Sent: 18 May 2018 12:31
To: Planning Scanning
Subject: FW: Acknowledgement of Planning Application: BR/63/18/PL : 77 Aldwick Road

From: Simon Davis
Sent: 18 May 2018 12:30
To: 'TONY PHEBEY'
Cc: 'Simon Royall'
Subject: RE: Acknowledgement of Planning Application: BR/63/18/PL : 77 Aldwick Road

1357/P03 B

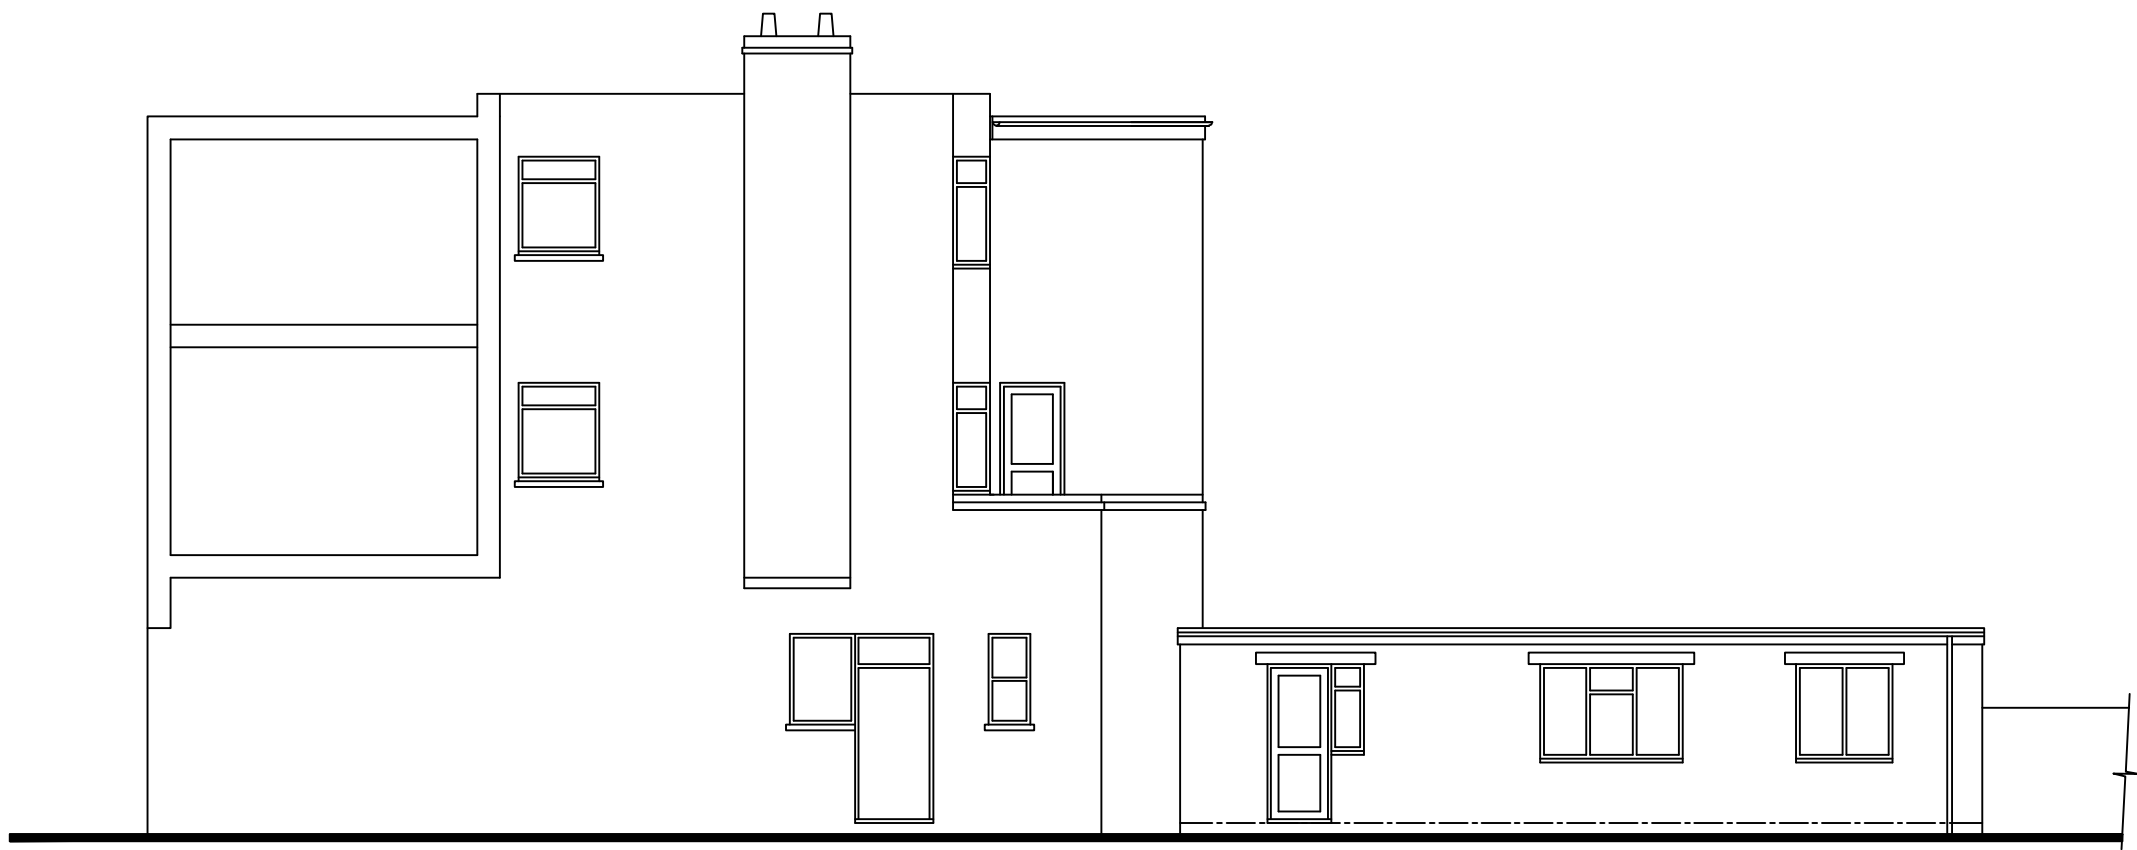
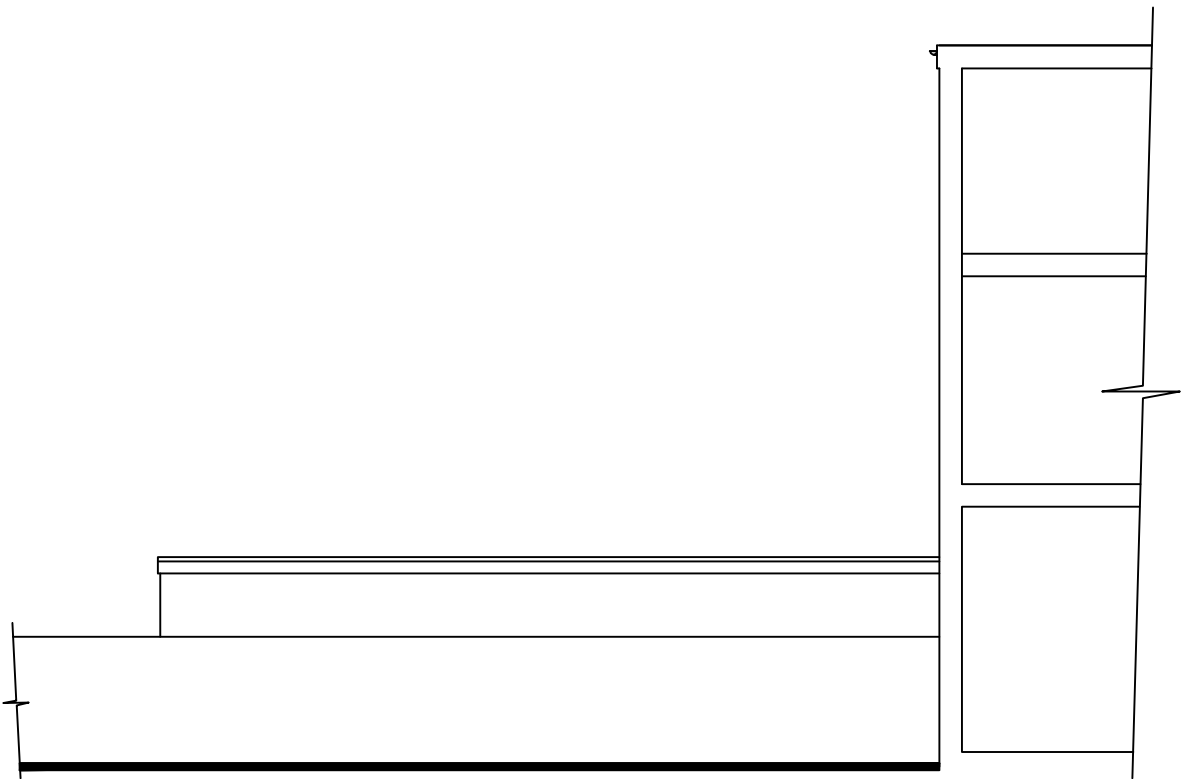
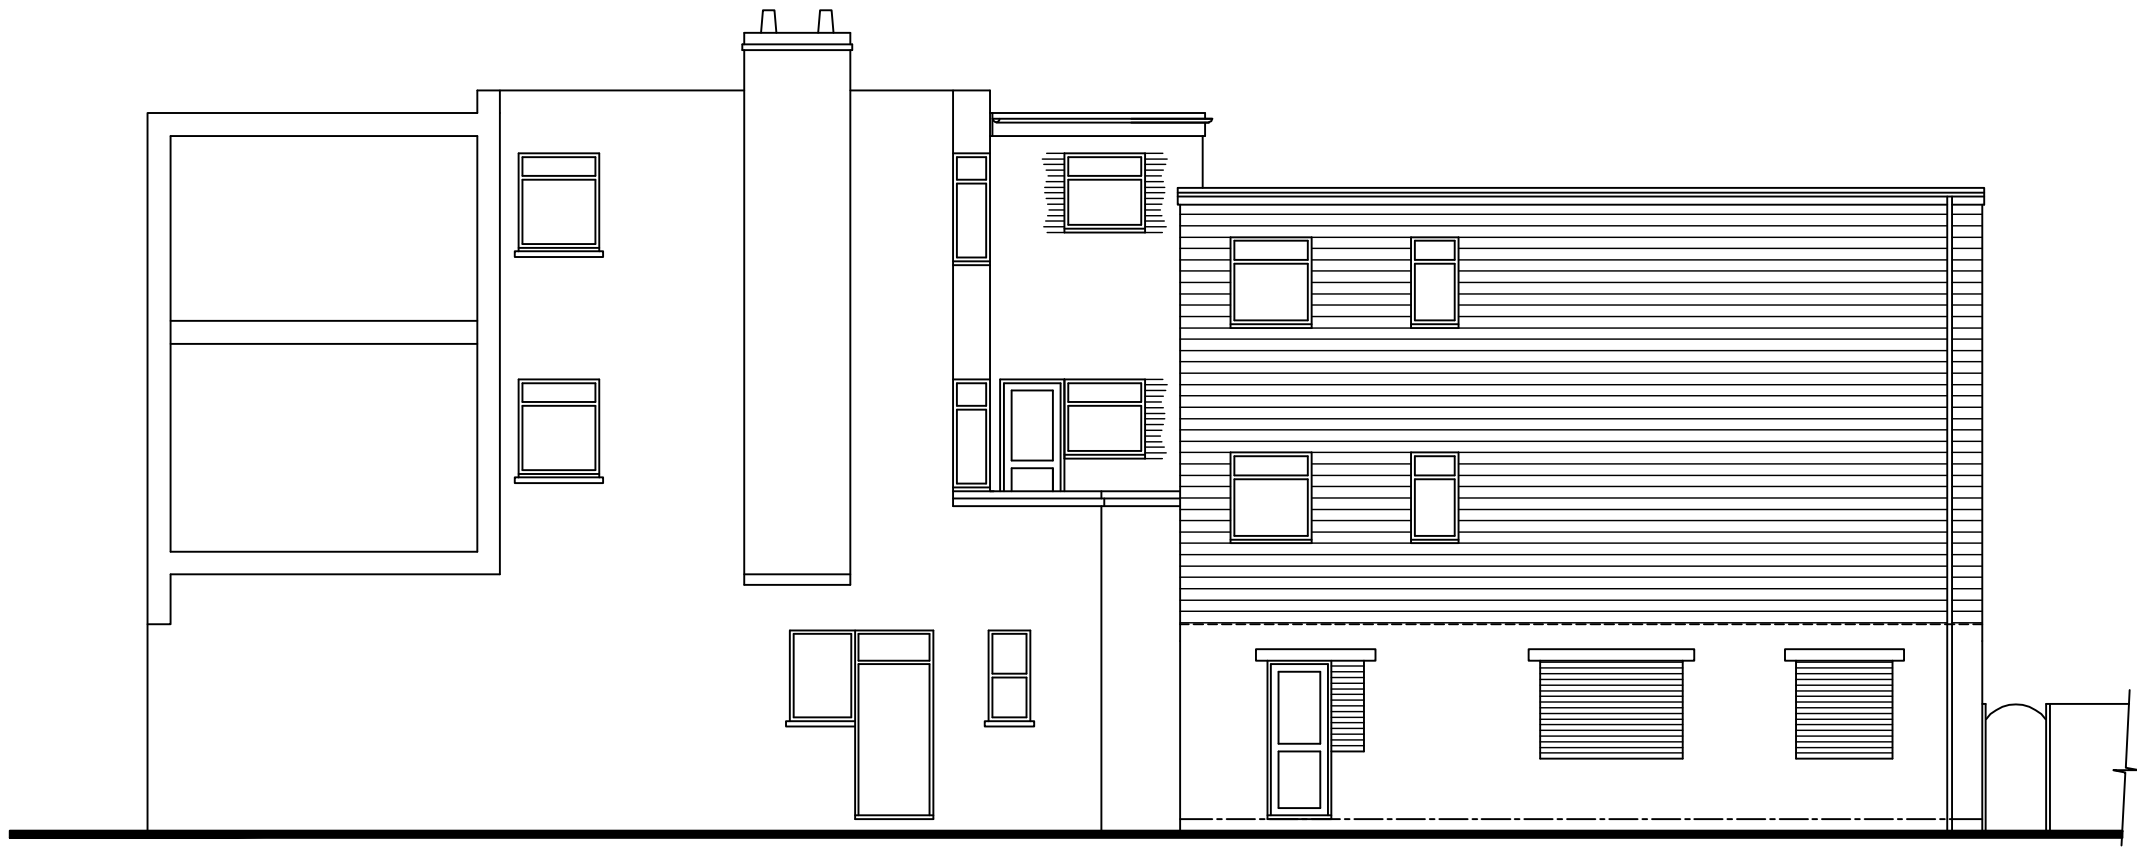
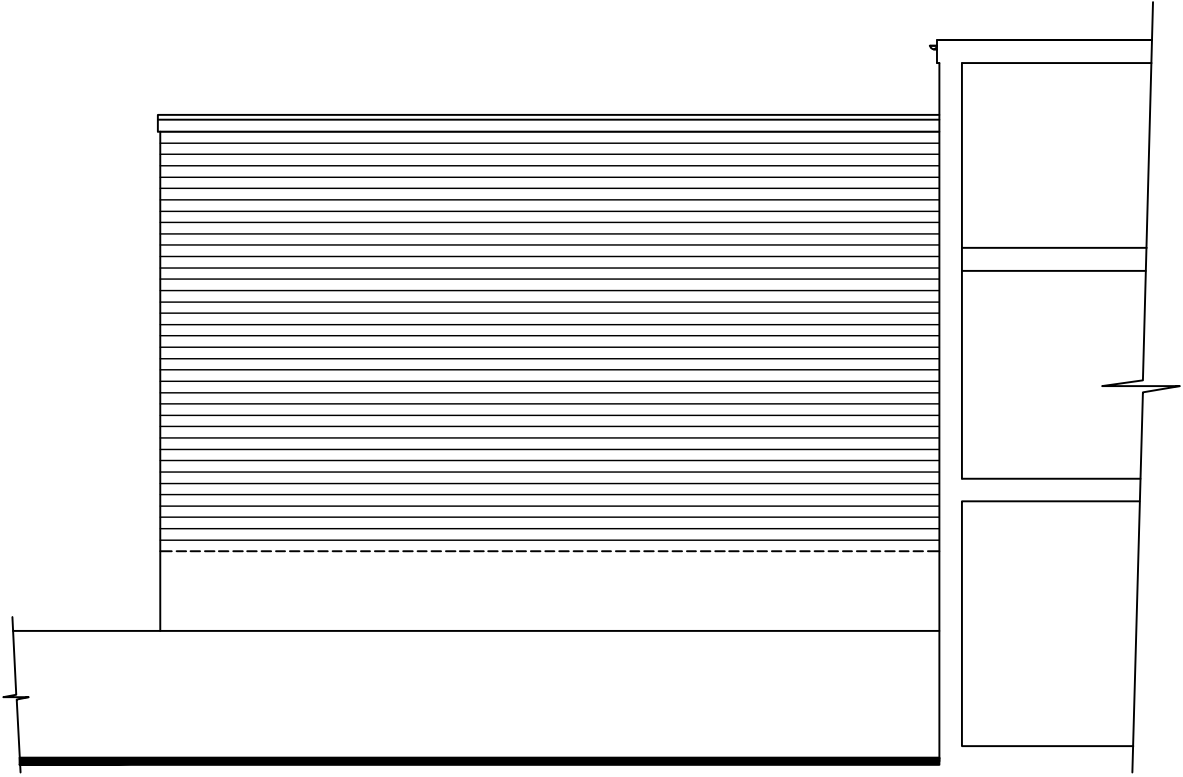
I have visited the site as part of the application process and thus have assessed the relationship with the neighbouring residential properties. I consider this to be unacceptable.

Notwithstanding the above, I have assessed the application and can confirm that we be looking to refuse the application based on harm in terms of being overbearing and a loss of light/overshadowing to the amenity of those neighbouring residential flats within 75 & 79 Aldwick Road.
